EPC STORMWATER REVIEW COMMENTS
IN ORANGE BOXES WITH BLACK TEXT

ESTATES AT CATHEDRAL PINES

STREET IMPROVEMENT PLANS

ESTATES AT CATHEDRAL PINES		HORIZONTAL CONTROL PLAN		SHEET 4 OF 8		JOB NO. 25260.00	
H-SCALE		V-SCALE		DATE		DESIGNED BY	
1"=80'		N/A		05/15/24		APL	
BY		DATE		NO.		REVISION

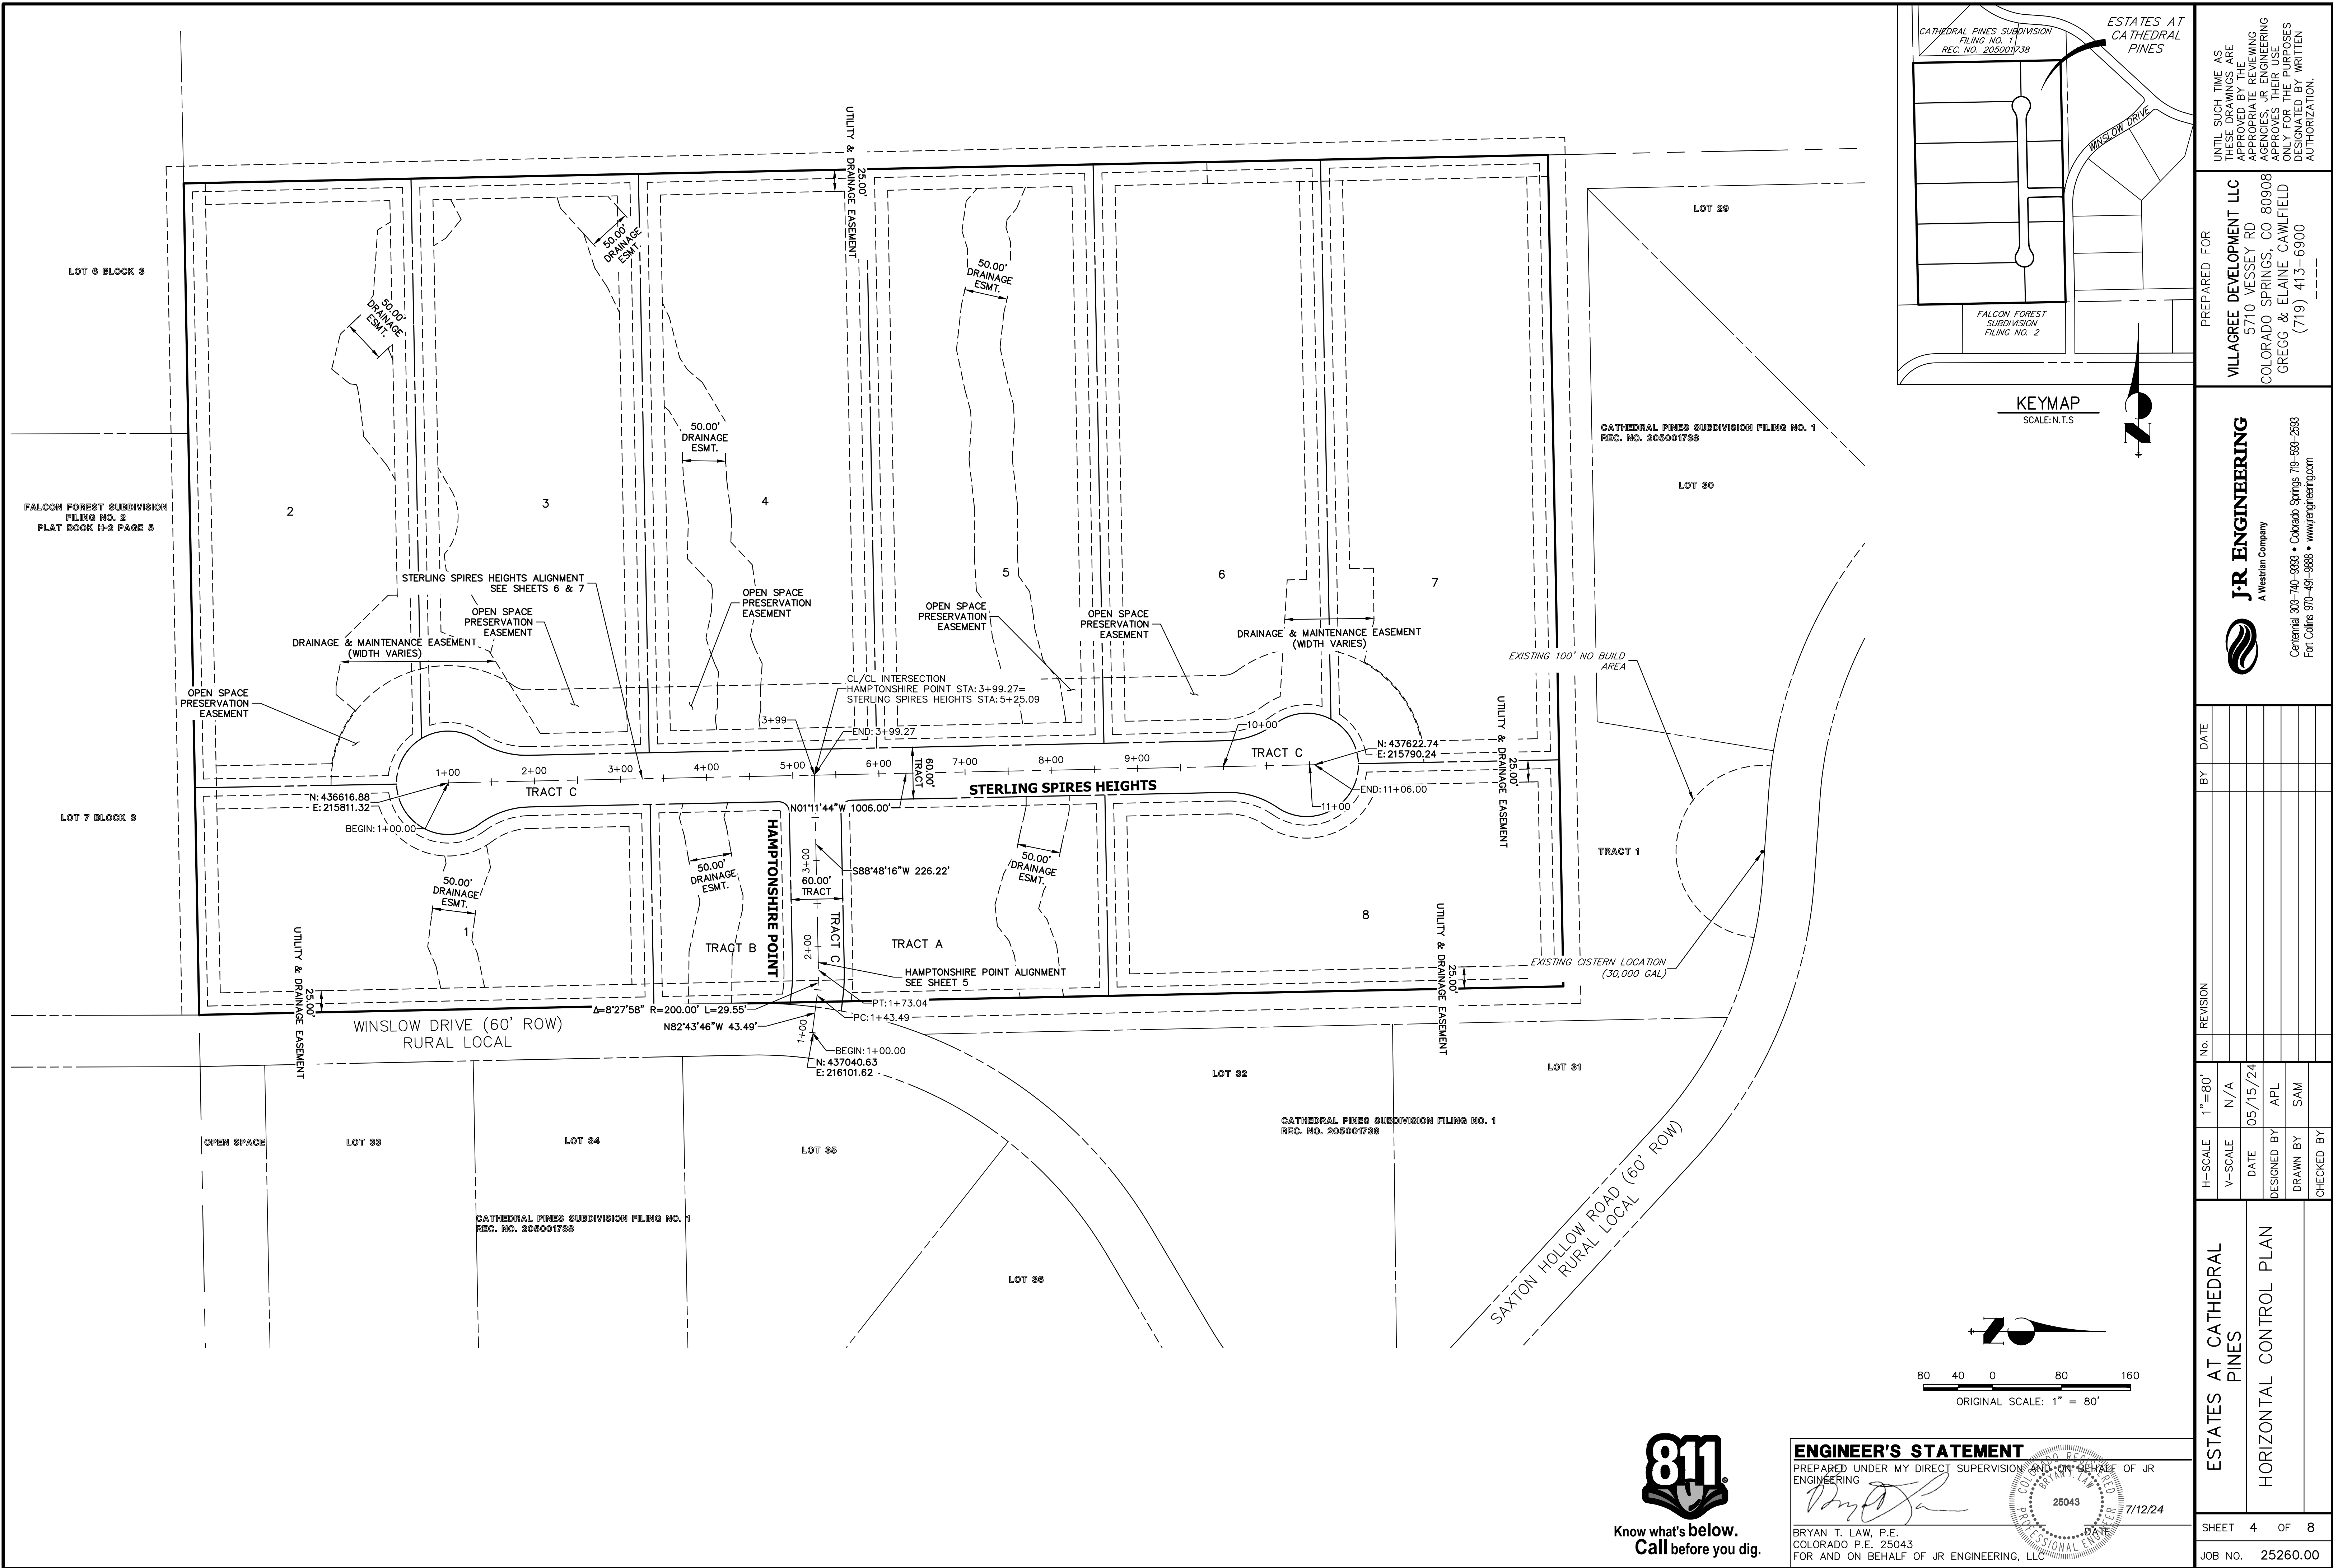
Include a cistern location and easement and turn around area (missing)
